## **Great North Road Solar and Biodiversity Park**

Statement of Common Ground with Nottinghamshire Wildlife Trust

Document Reference – EN010162/APP/8.[44A11B](#)

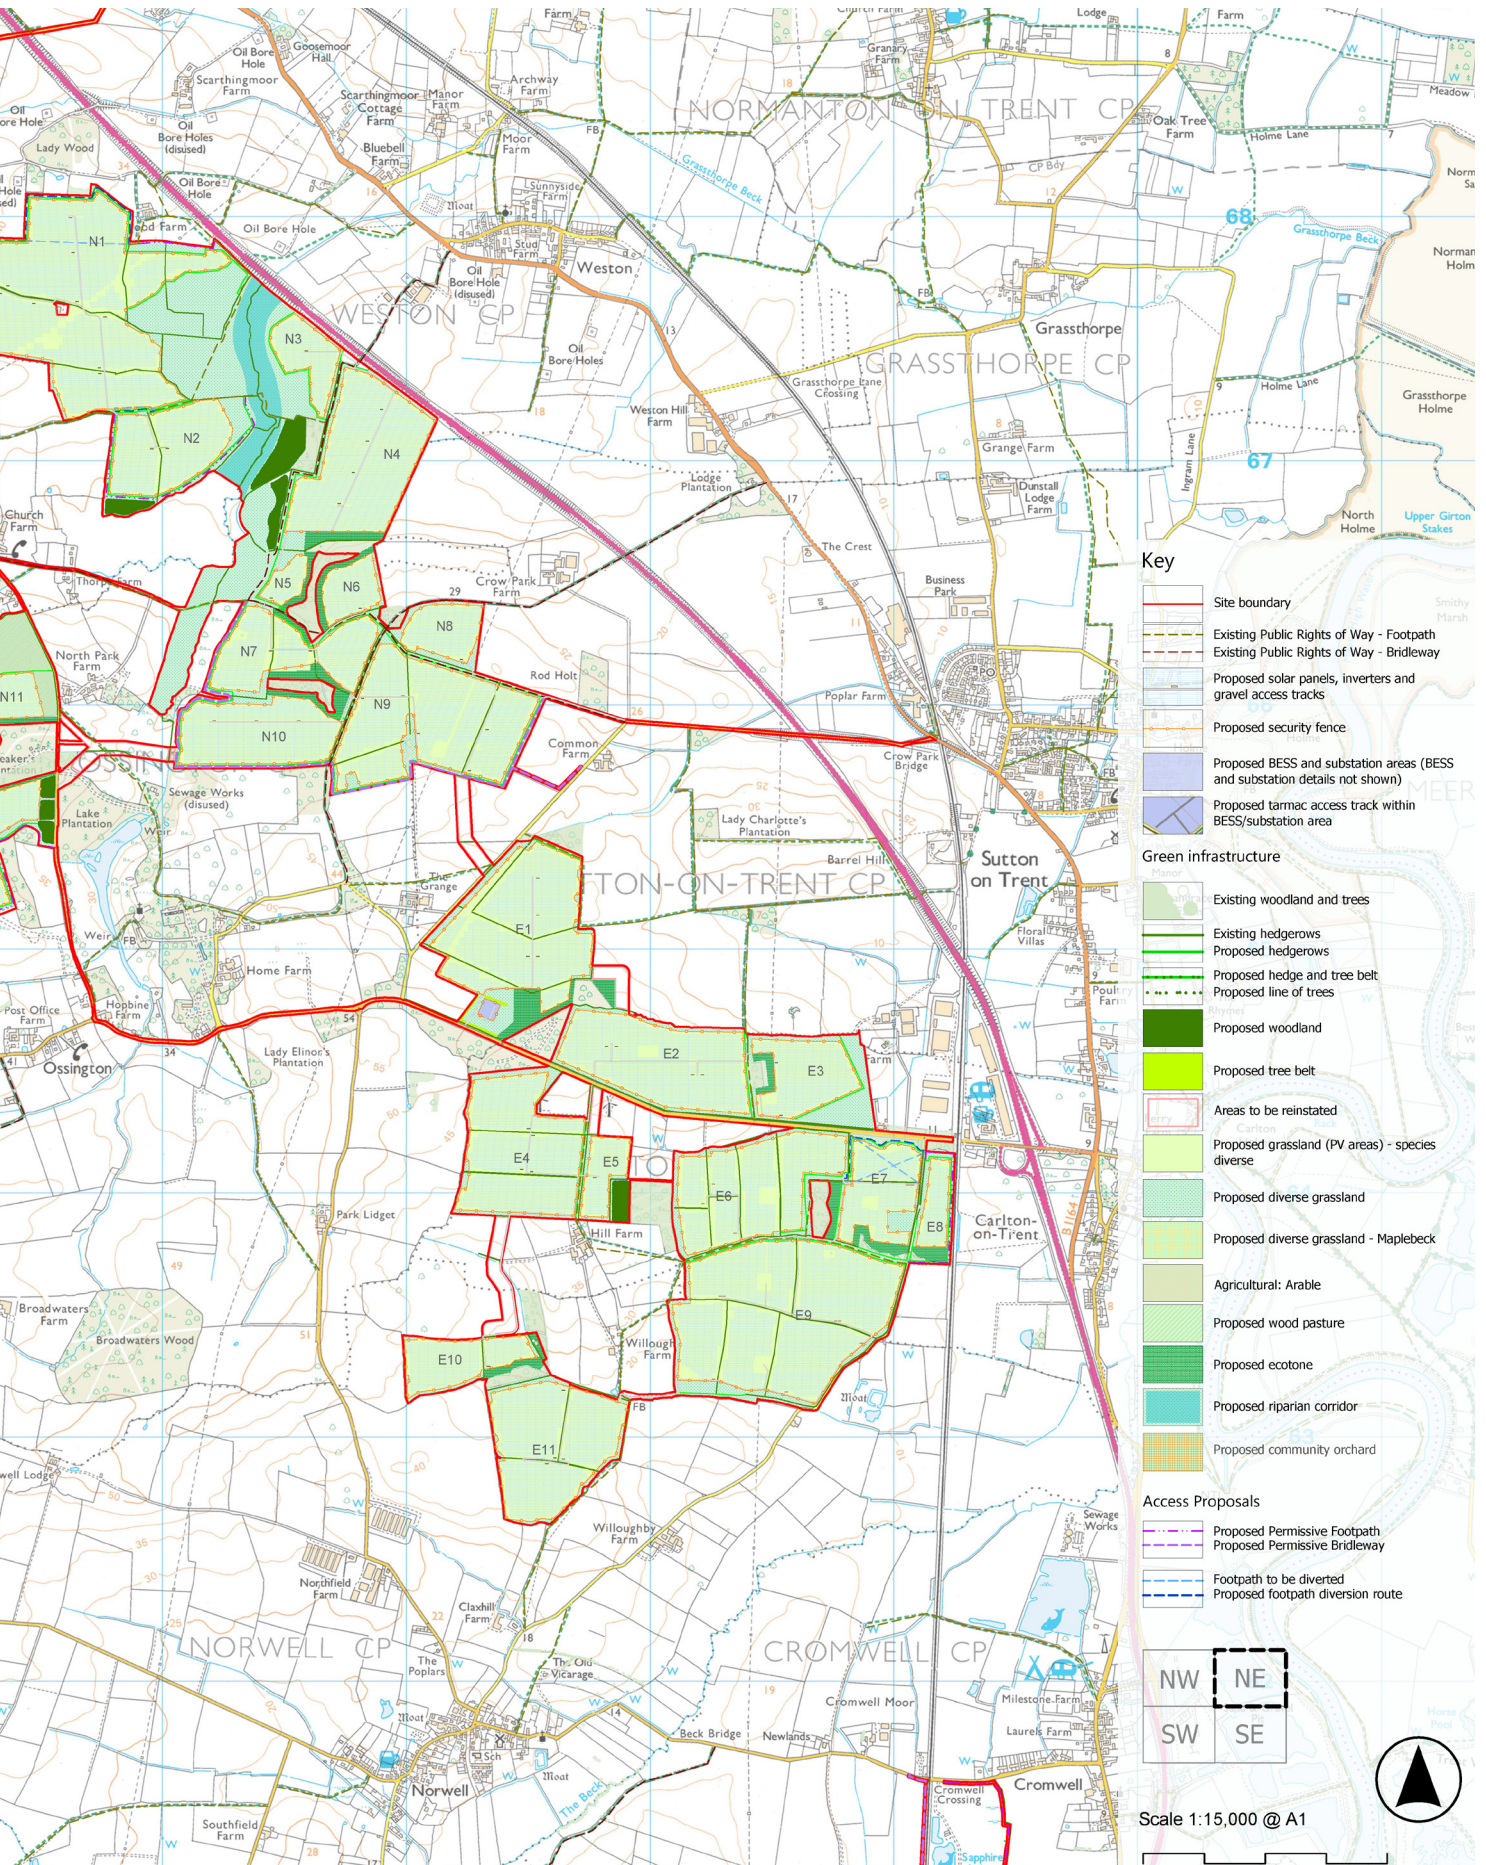
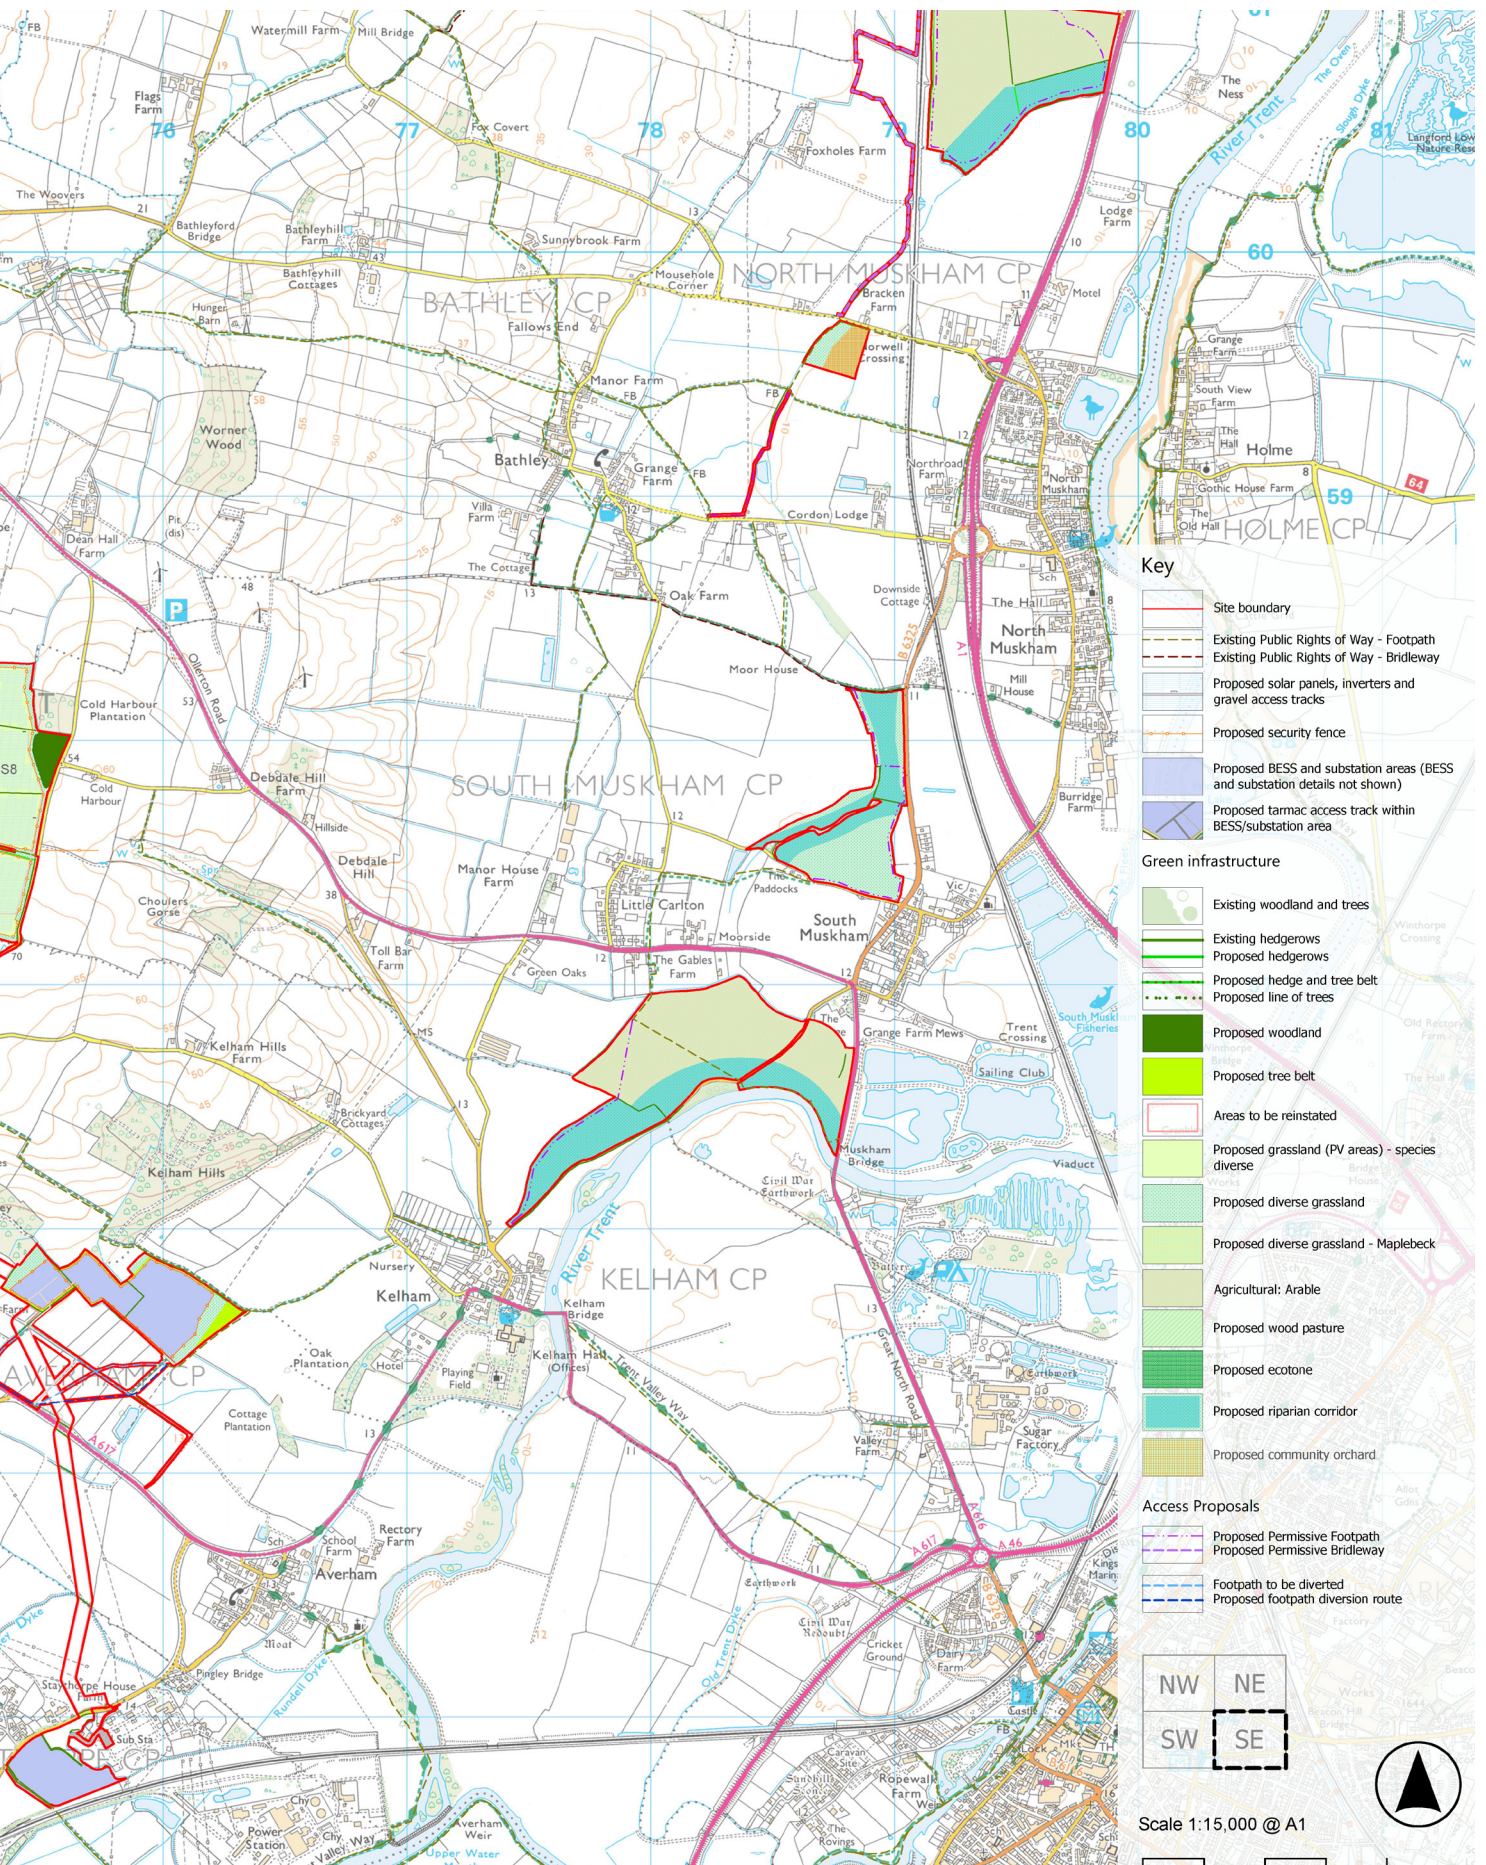
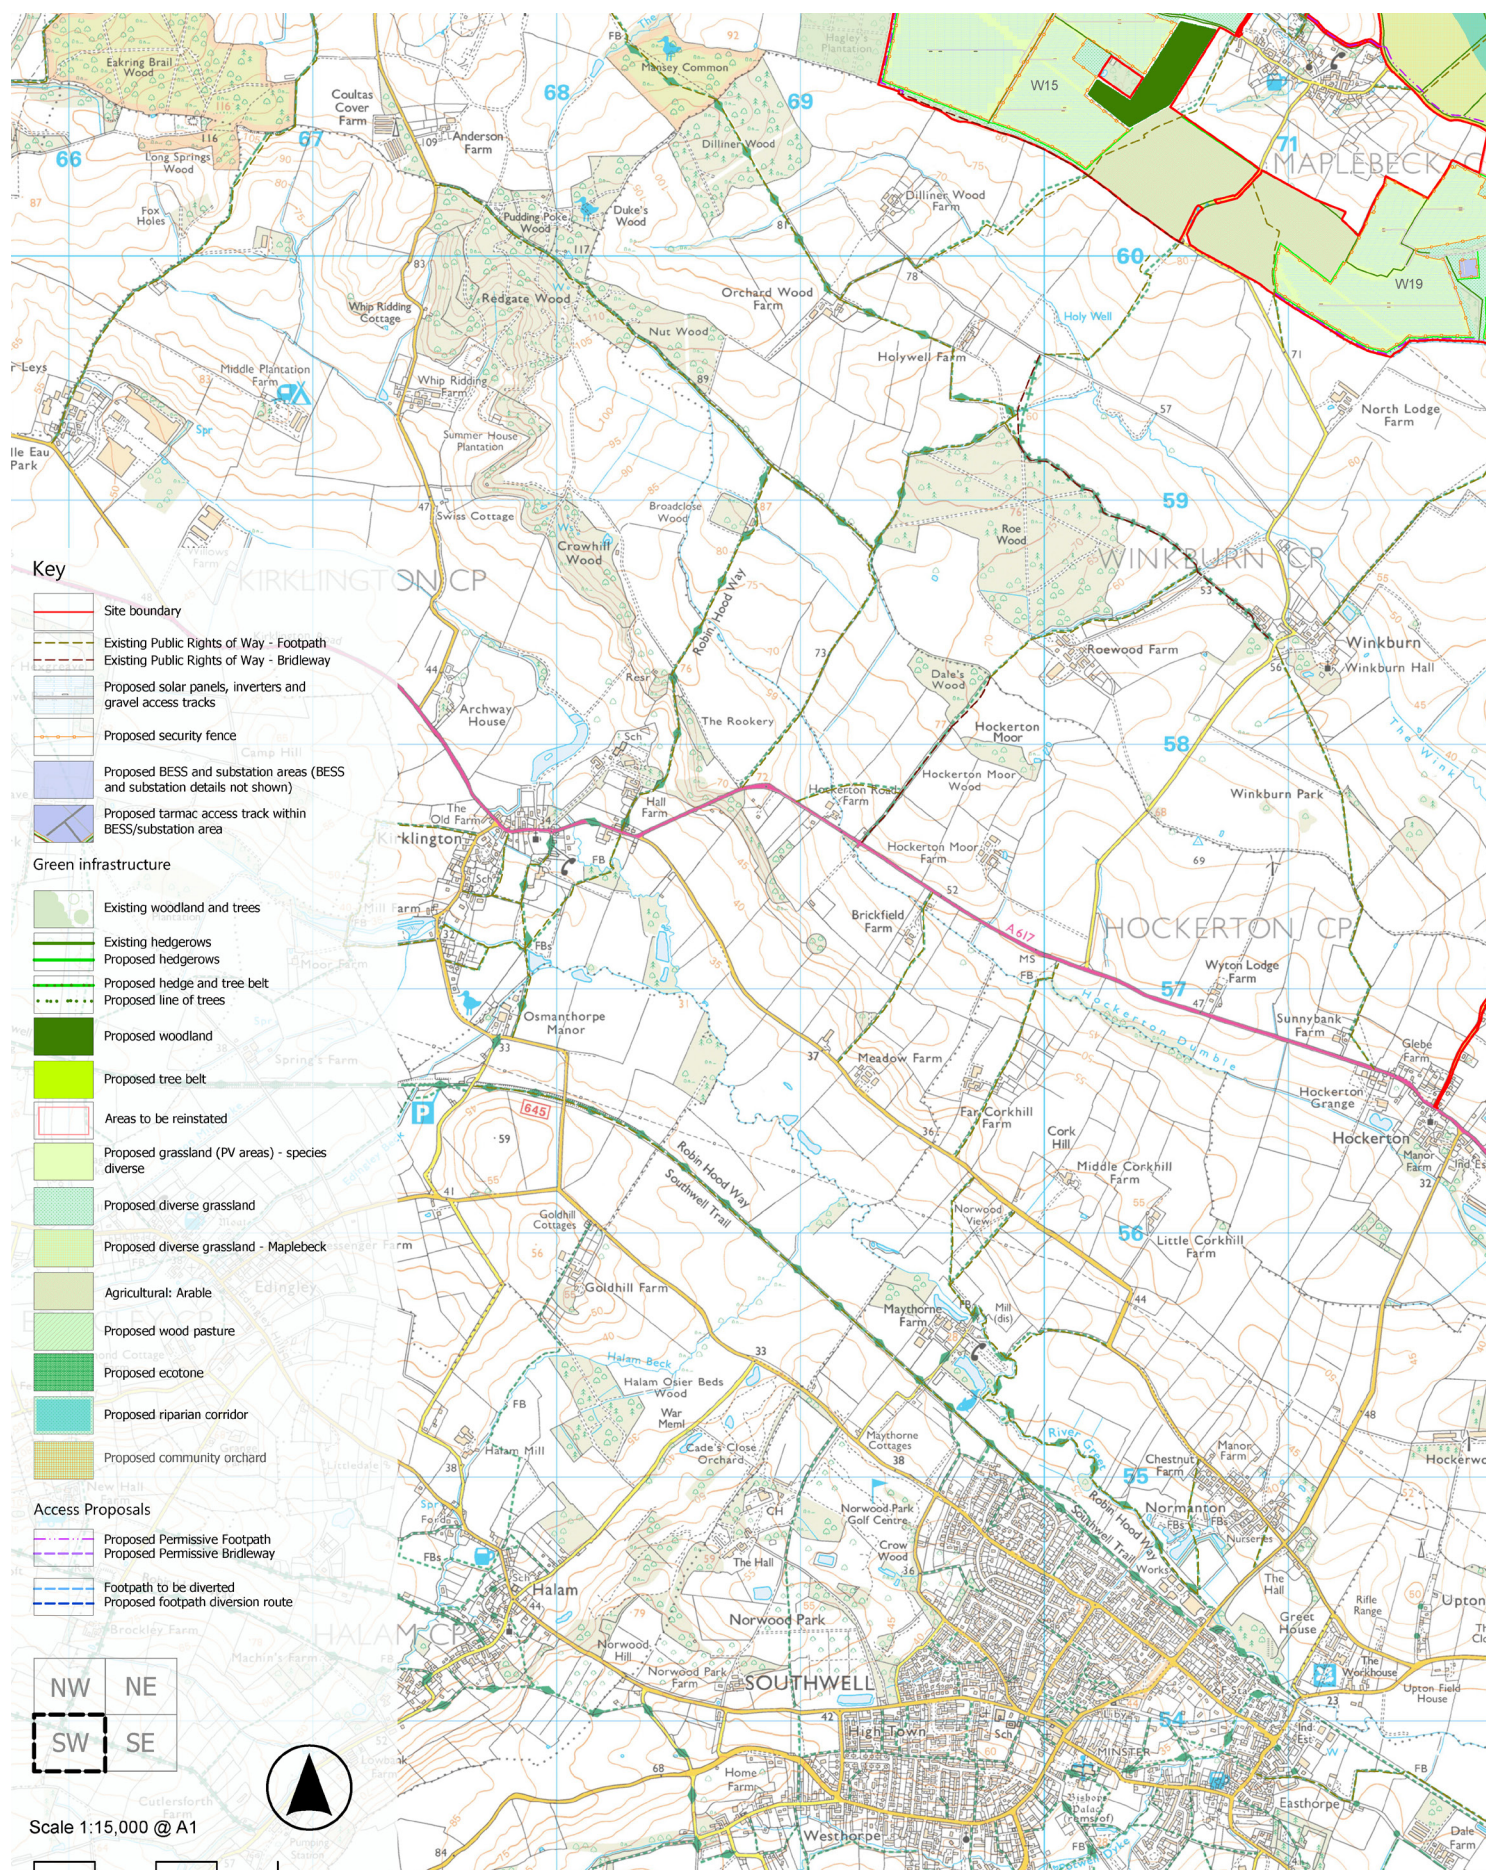
2.2.3	<u>Meeting (27/01/2026)</u>	<u>Scattered tree planting</u>	<p><u>Concerned that tree planting in or near open areas would discourage nesting birds such as lapwing and waders. Recommend that black poplar is</u></p>	<p><u>The specification of the tree planting in the riparian corridor has been revised in section 22 of Table A5.1.5 in ES Volume 4, Appendix A5.1: Outline Landscape and Ecological</u></p>	<u>Agreed</u>

Ref	Relevant Documents	Description Of Matter	<u>Applicant's Nottinghamshire Wildlife Trust's Position</u>	<u>Nottinghamshire Wildlife Trust's Applicant's Position</u>	Status
			<u>included in the tree planting specification.</u>	<u>Management Plan (LEMP) [EN010162/APP/6.4.5.1C] to make clear that the locations of tree planting will be selected to limit their potential to discourage nesting birds. The locations shown on the Masterplan are therefore purely indicative. Black poplar has been added to the specification.</u>
